**From:** Theo Polizogopoulos  
**Sent:** Wednesday, 28 January 2026 4:36 PM  
**To:** Rose-Anne Hawkeswood  
**Cc:** Brittany Golding  
**Subject:** RE: Narrabri Gas Lateral Pipeline EIS - DCCEEW Comments  
**Importance:** High

Our pipeline subject matter experts have conducted a preliminary review of the EIS for the Narrabri Lateral Pipeline project and provide the following feedback and comments for your team's consideration;

Figure 2.4 Project corridor options

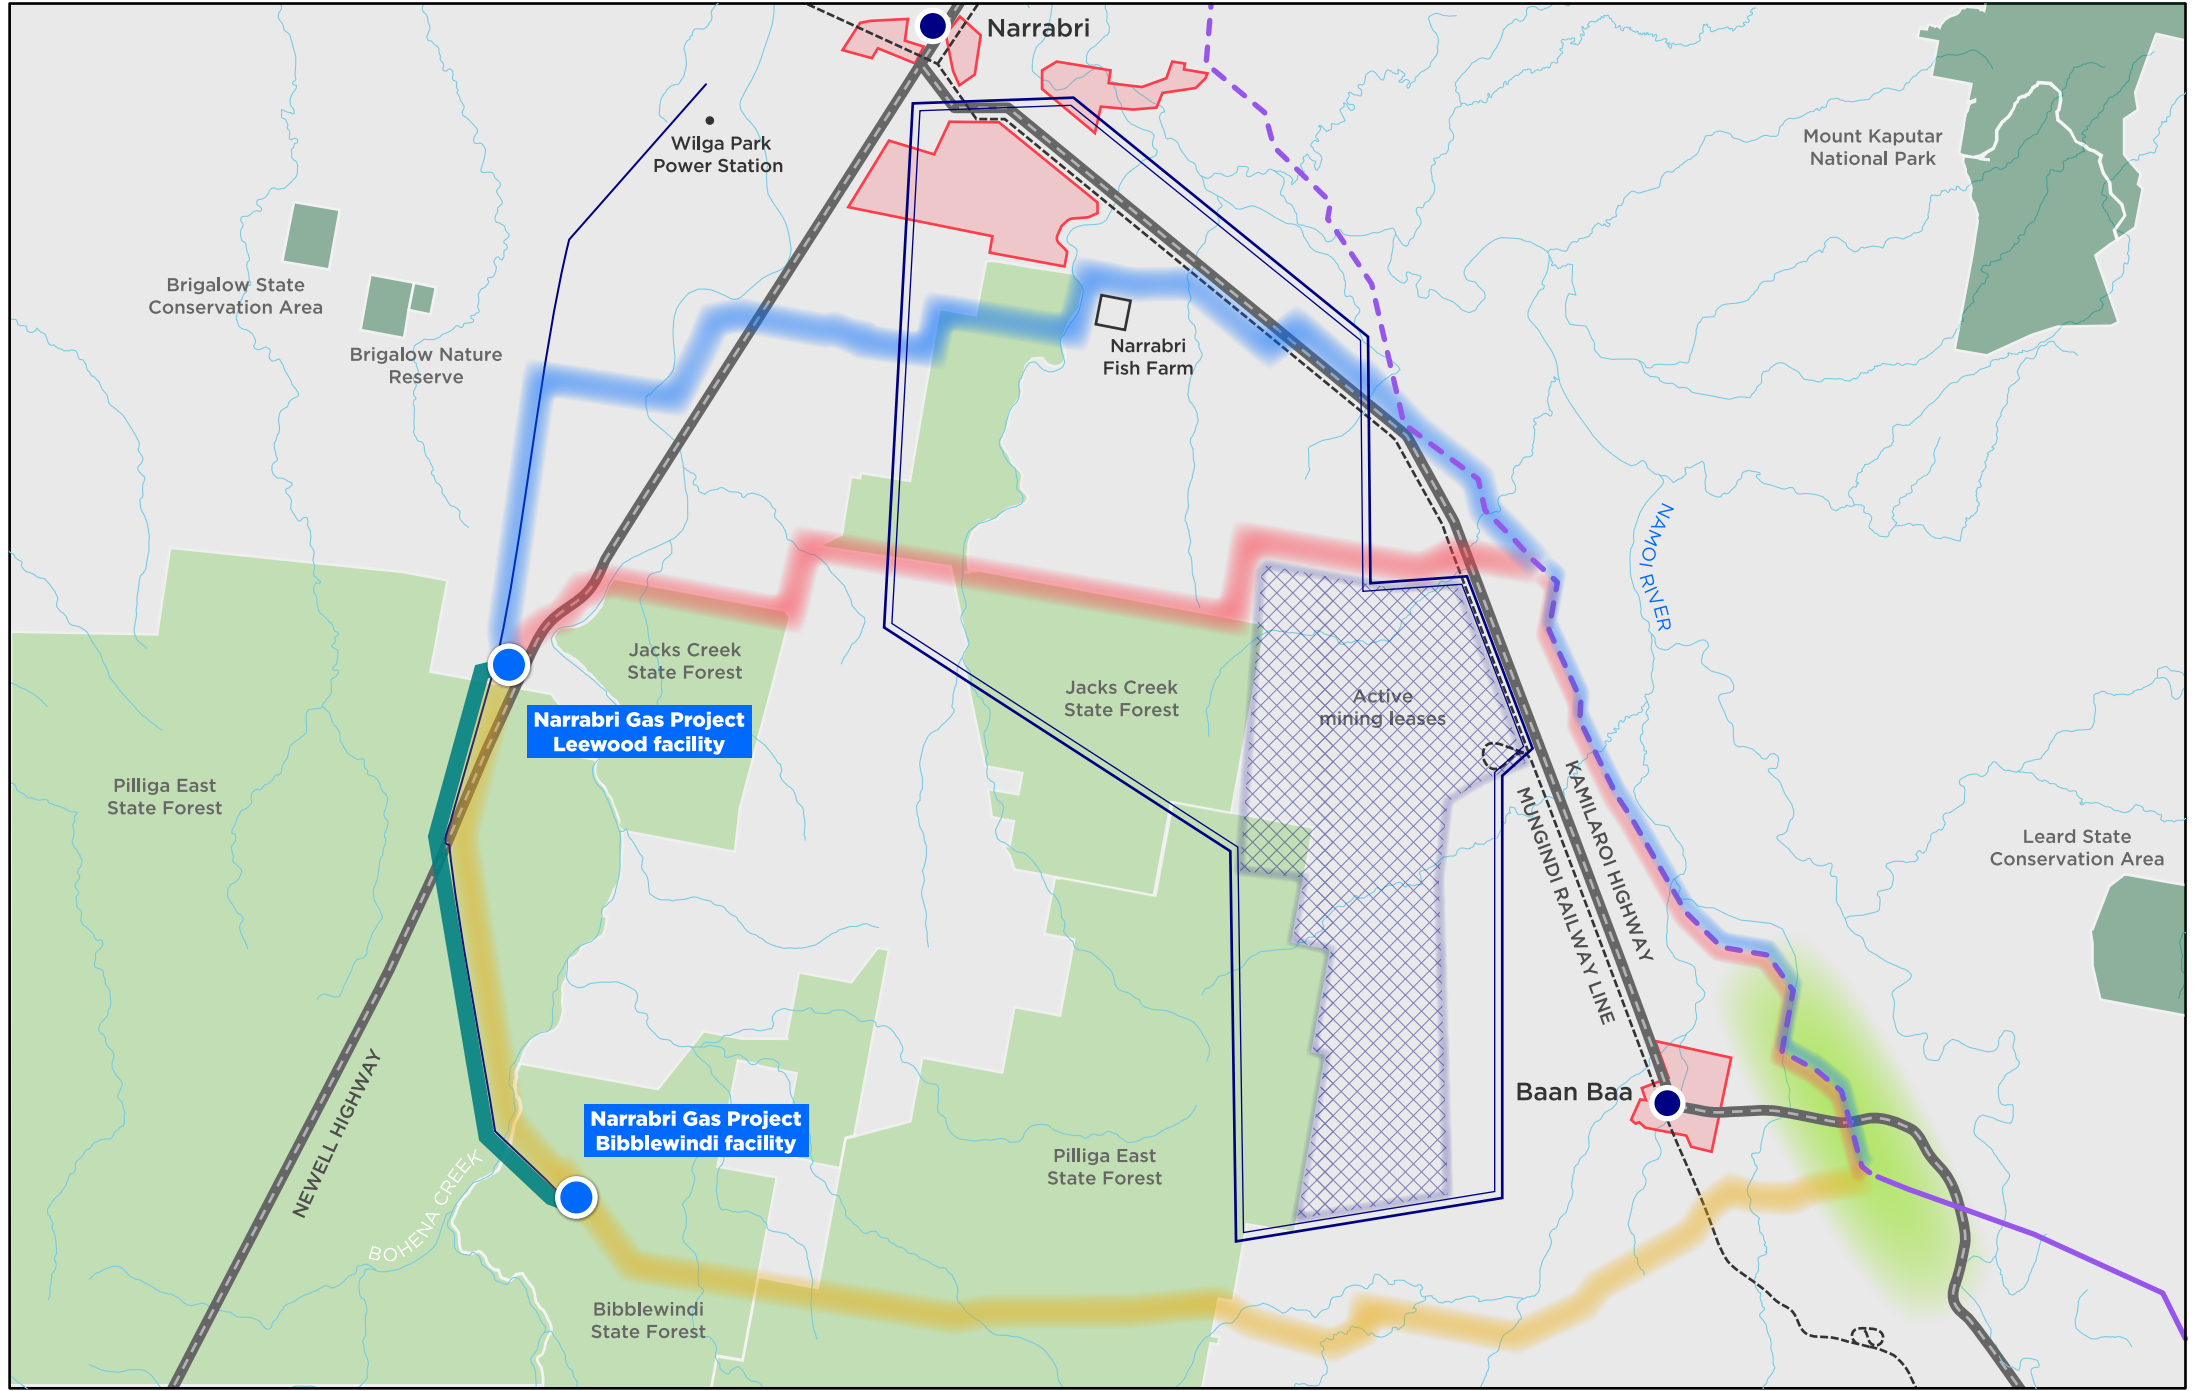
1. It appears that the route selection is driven by constructability rather than risk avoidance. It would be great if Santos can provide more details on how environmental sensitivities influenced the final alignment of Narrabri lateral Pipeline.

- a. It would be interesting to get Santos' feedback on whether alternative routes were considered to avoid environmentally sensitive or high-risk areas (e.g., wetlands, landslide-prone terrain, corrosion-prone soils).

- b. Does the finalised route cross protected habitats, drinking water catchments, unstable land (e.g. slopes, ravines, escarpments, etc), or floodplains where a pipeline failure would have disproportionately severe impacts? If so, what measures does Santos intend to take to control this risk?
